Historic England

**Arrangements for Handling Heritage Applications Direction 2015  
& T&CP (Development Management Procedure) (England) Order 2015  
& Planning (Listed Buildings & Conservation Areas) Regulations 1990**

**LAND TO THE NORTH OF CASTLE STREET AND SOUTH EAST OF  
WATERHOUSE LANE INCLUDING CASTLE BUILDINGS AND THE EARL DE  
GREY PUBLIC HOUSE, KINGSTON UPON HULL, HU1 2DA  
Application Nos 19/00334/LBC & 19/00333/FULL**

Fig 9: Earl de Grey Ground Floor Plan (approx. extent of listing in red)

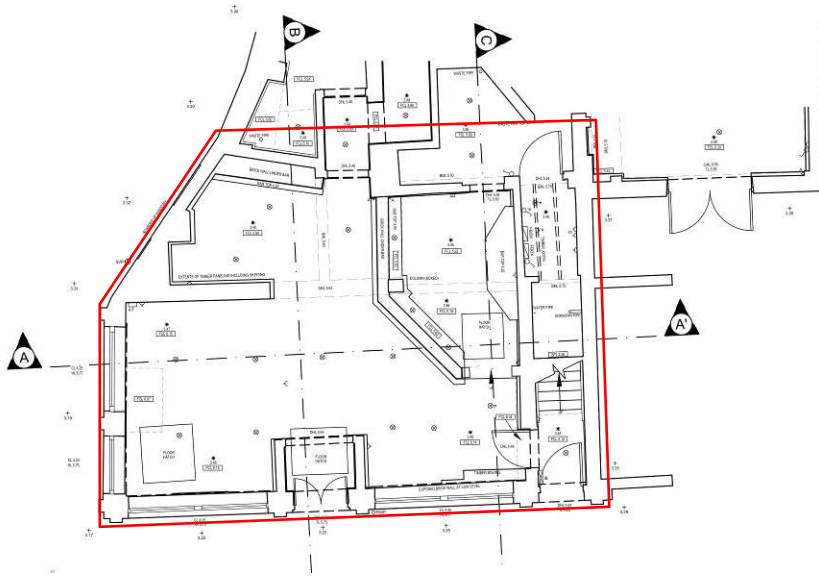
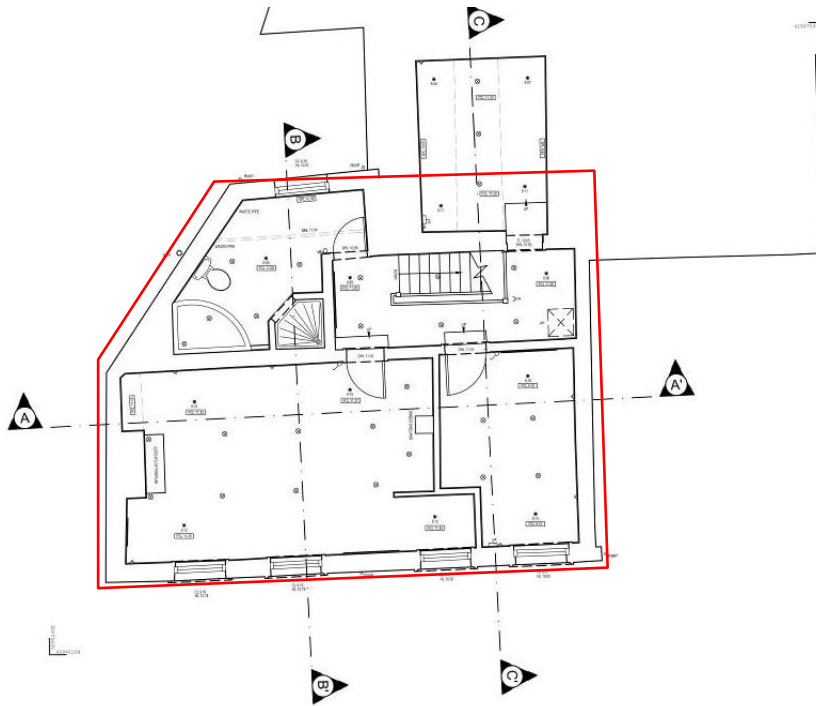
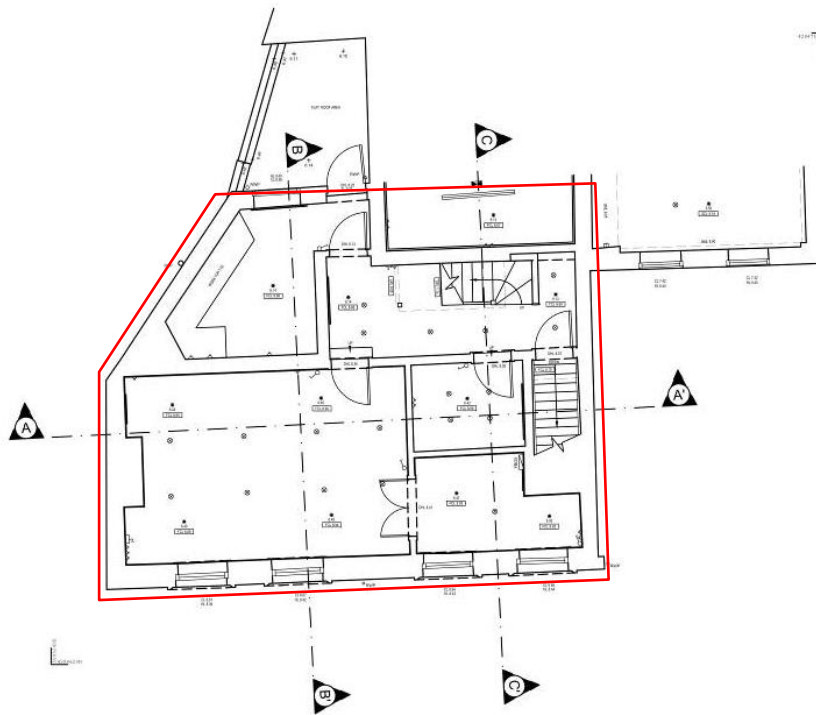
- The re-erected the Earl de Grey should be brought forward so that the frontage is 'back of pavement' in the traditional manner, flush with the Castle Buildings. This is in order to ensure its prominence in the streetscape is fully achieved.

- More of the external form and principal walls of the listed building should be rebuilt to ensure the legibility of the building envelope so that it reads as separate from the Castle Buildings.

- The proposed internal layout of the repositioned Earl de Grey as proposed does not respond positively to its significance. A major portion of the interior is proposed to be used for a new staircase which compromises the amount of useable space. We advise that a new staircase should be smaller, ideally a bespoke carpentry piece but if it needs to be larger we question whether the staircase could be reconfigured and relocated to the modern extension (glazed link building) thus removing this element from the listed part of the building.

- The proposed elevations should be revisited so that the fenestration matches the existing, including the proportions of the chimney stack.

- The new main entrance doors should be double doors to a traditional design.
